**Your ref: 3/2023/0118; 8 Hammond Drive, Read BB12 7RE**

Further to your letter dated 22 February 2023, we write to object to the retrospective planning application number 3/2023/0118 and invite the Council to require the development to be constructed in accordance with the approved applications 3/2021/0428 and 3/2021/1074. We would not have agreed to the original applications had the property been constructed in the way that is now being proposed.

Drawing Title		
Proposed Floor Plans		
Scale	Date	Drawn
1:100 @ A1	April 2021	Craig Harrison

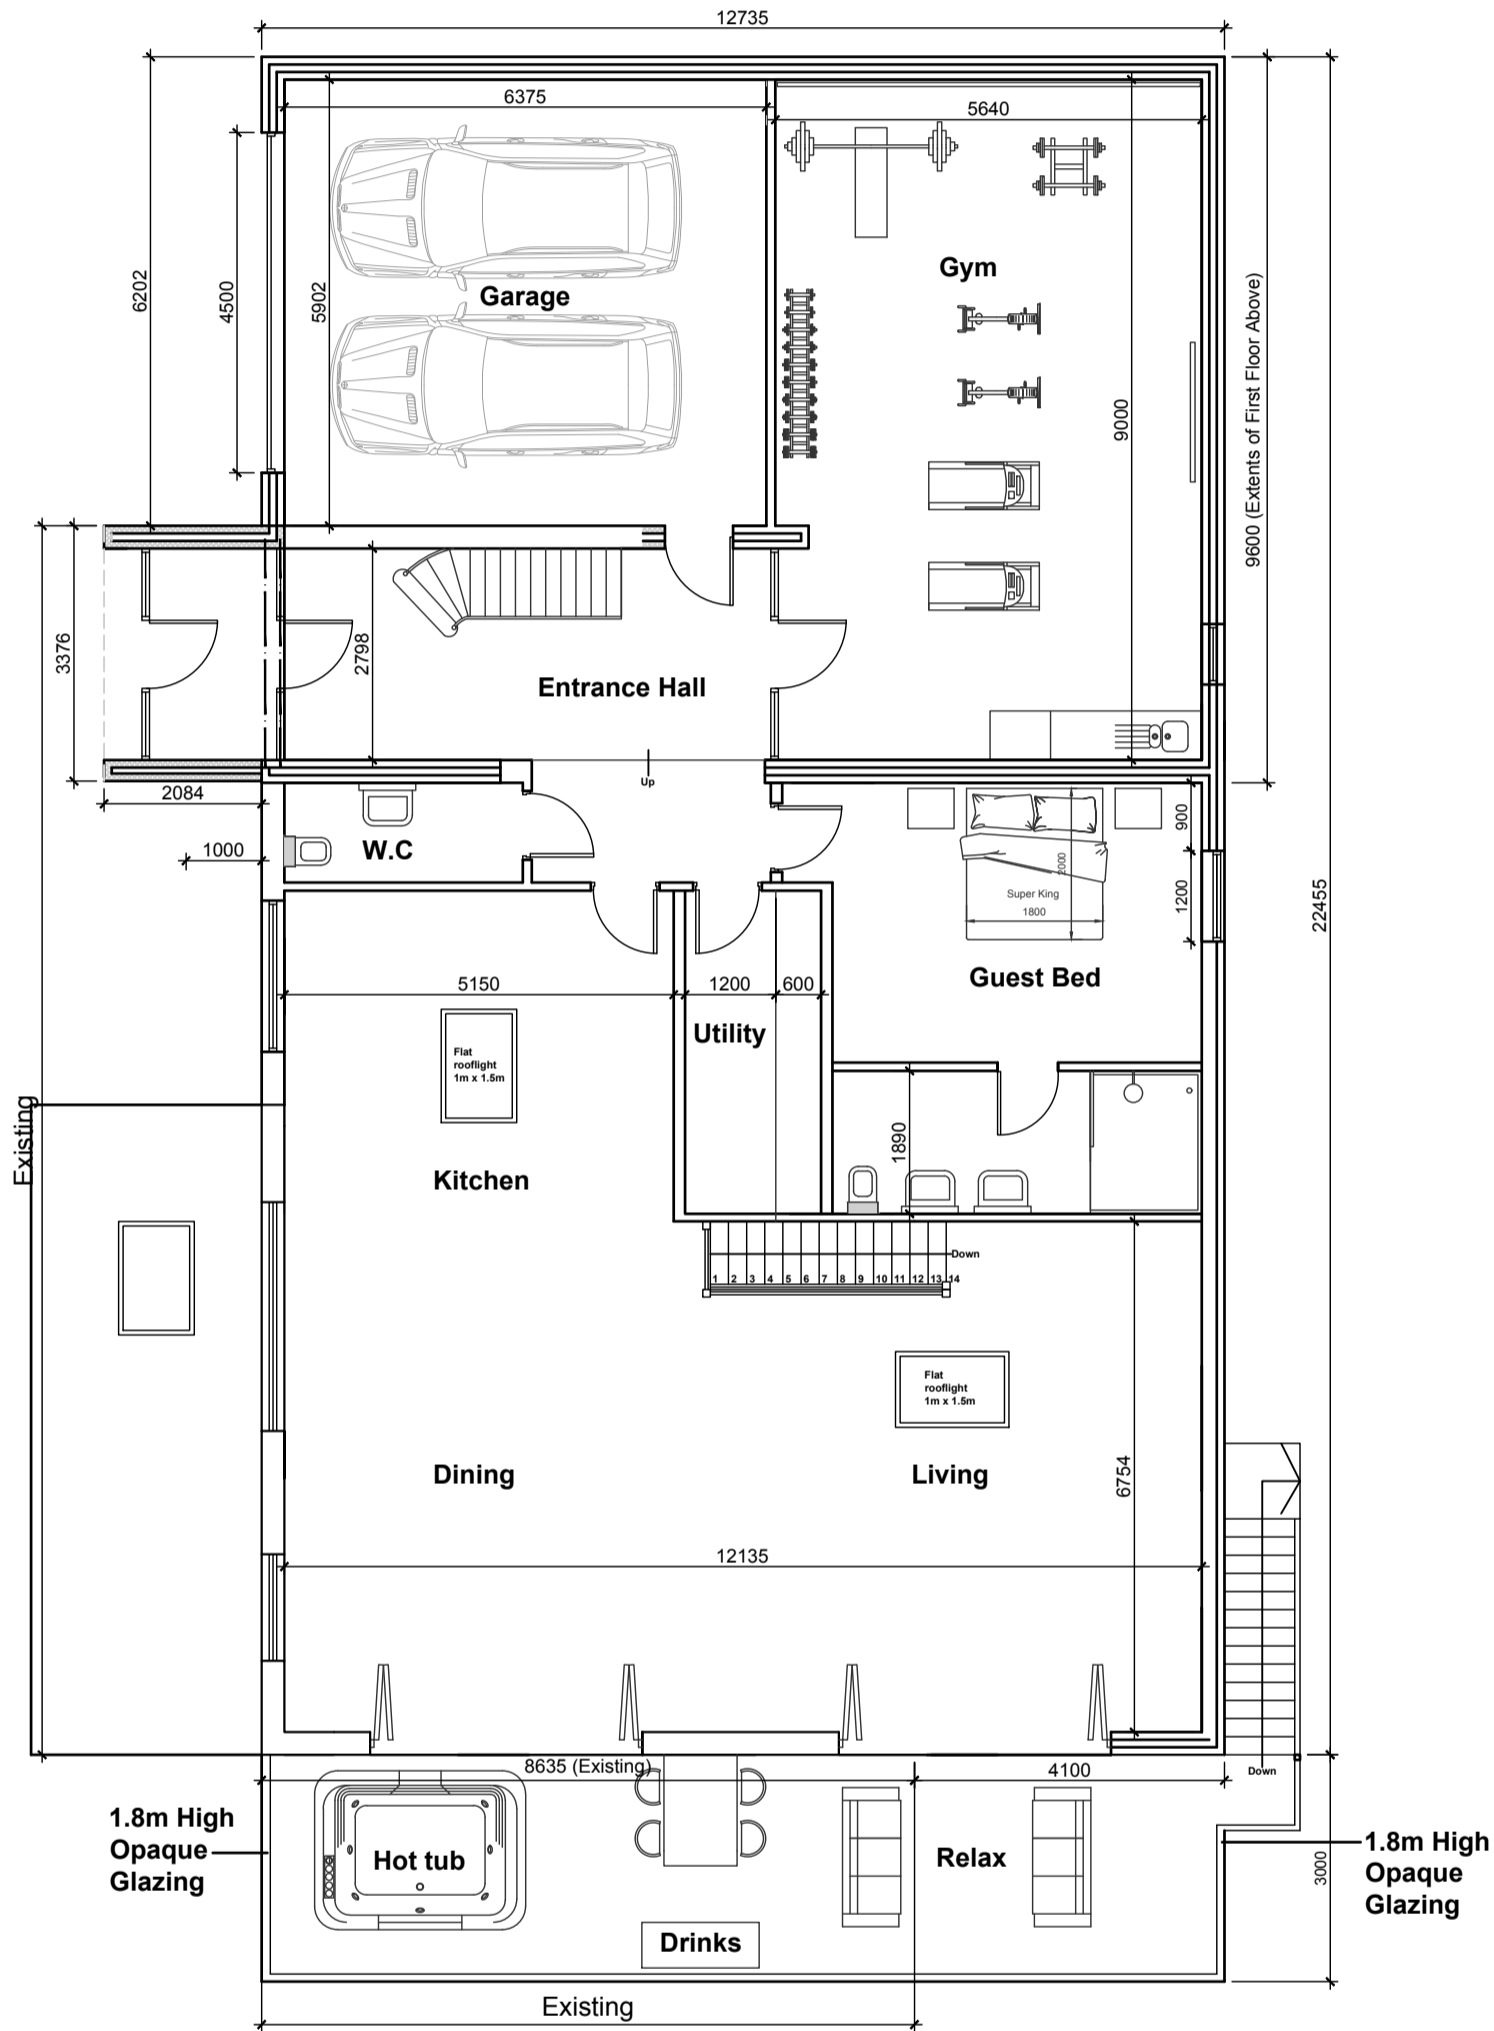
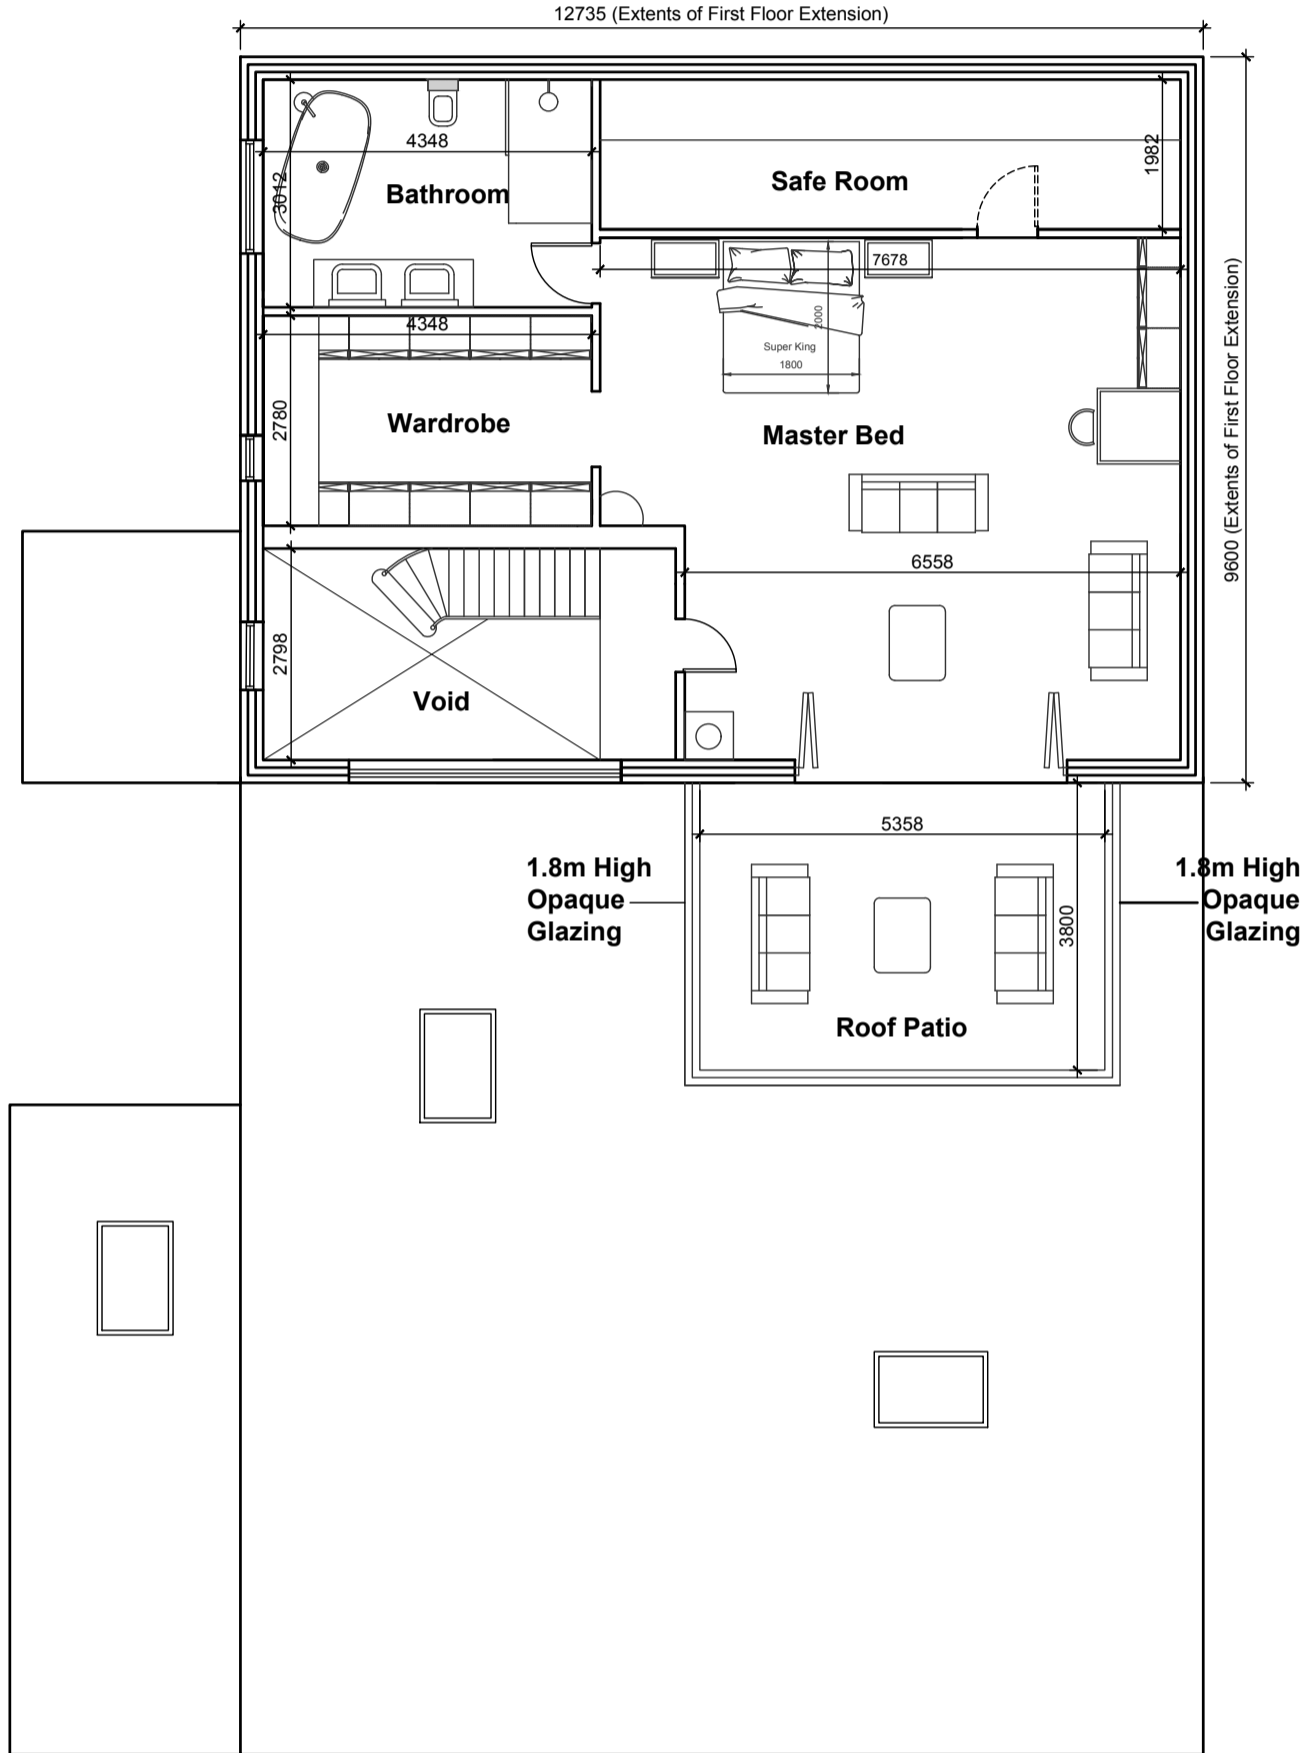
We object to the addition of a second window to the eastern wall. Given the way in which this property is being developed, [REDACTED] that it will be built according to the approved plans. [REDACTED]

Client			
Mr John Houston			
Job Title			
Proposed Alterations to 8 Hammond Drive Read			
Drawing Title			
Boundary Treatment and Landscaping Planning Condition			
Scale			
Various @ A1	Date	October 2021	Drawn
			Craig Harrison

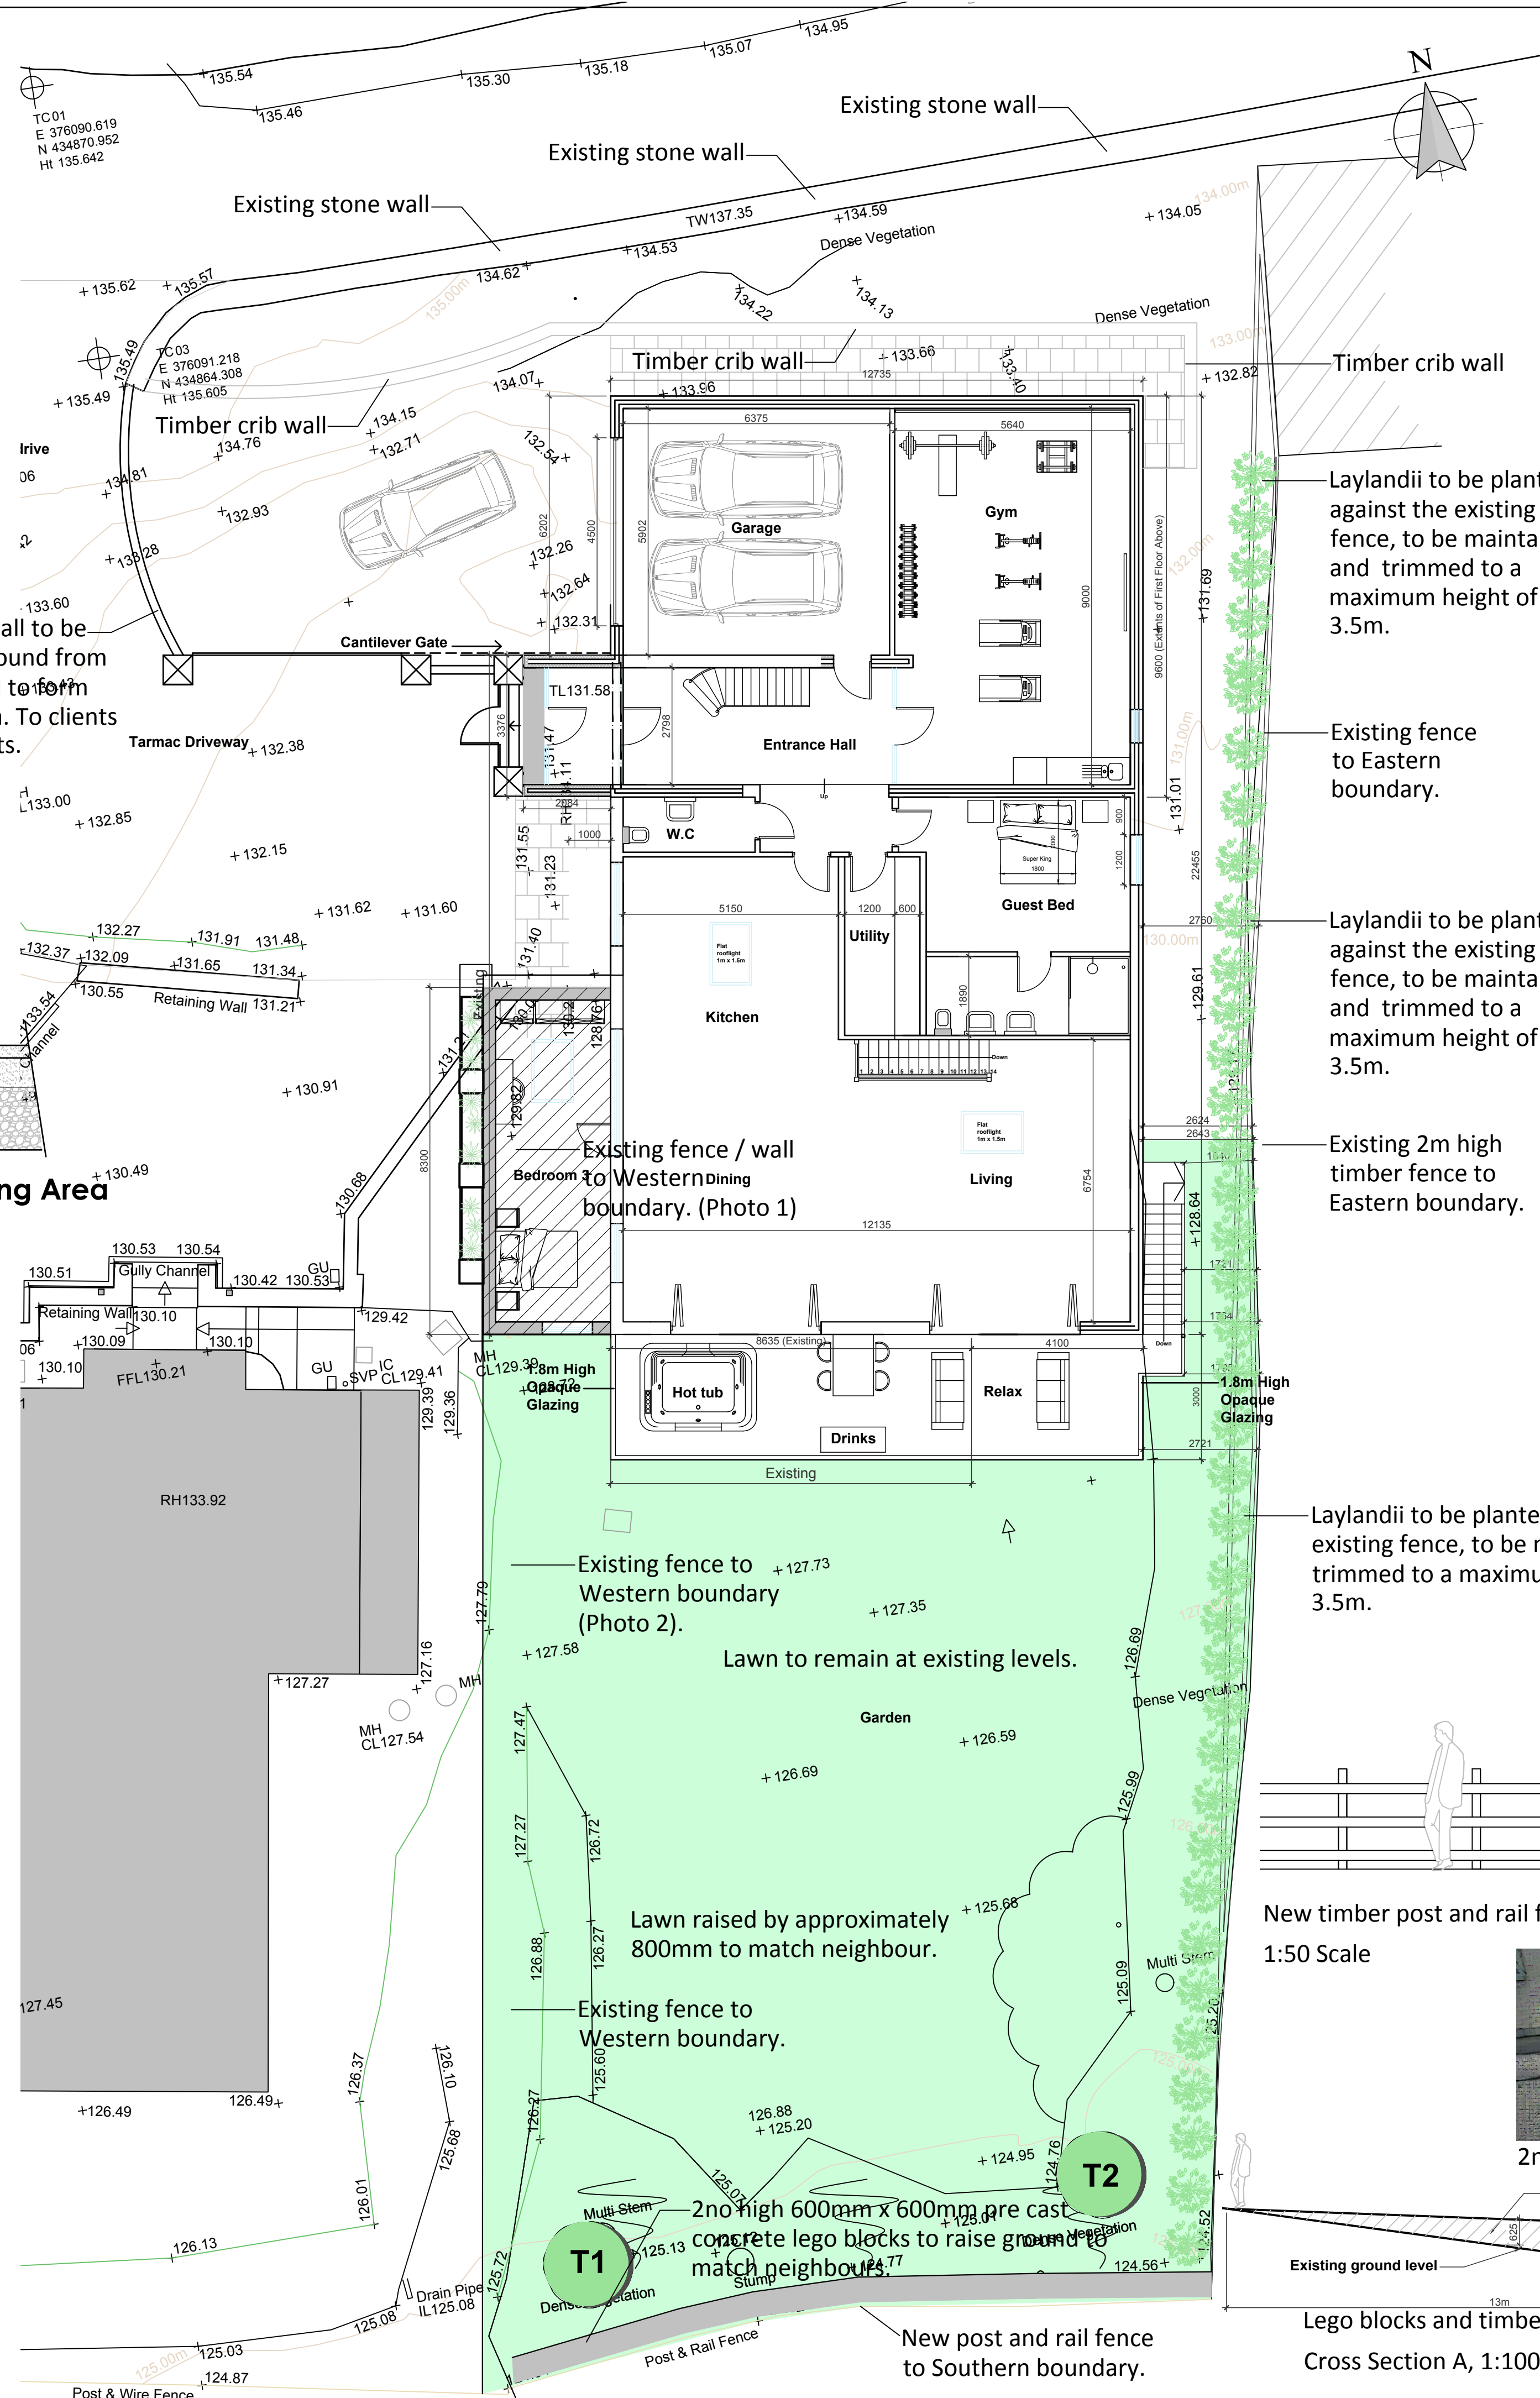
Contrary to the approved applications, the entire wall to the eastern side of the development has been constructed too close to the fence. The approved (and even the proposed) site plans require there to be a distance of 2-metres between the fence and the eastern side of the stairway (which has not to be constructed):

It is important to emphasise that the 2-metres is not to the eastern wall; it is to the east side of the stairway. This stairway has yet to be added to the eastern wall which will further impact on its proximity to the fence. The width of the stairway is not detailed on either plan but, according to scale, appears to be approximately 1-metre. Accordingly, the total distance from the fence to the eastern wall should be in the order of 3-metres.

The distance from the fence to the stairway is 1 metre 26cm; almost 85cm less than the approved application. As a result, the entire wall on the eastern boundary is almost 85cm closer to the boundary than was approved which impacts significantly on residential amenity.

The boundary with [REDACTED] used to be formed by a row of tall conifer trees which provided screening. To compensate for the loss of those trees there is a requirement to replant native tree species between the eastern face of the property and the fence. The following picture is taken from the 21 1116 Landscaping Scheme:

As a result of the eastern wall being constructed 85cm too close to the fence, there is now insufficient space to plant Laylandii to enable them to grow to 3.5 metres to provide screening of the property. This will compound the loss of residential amenity detailed above.
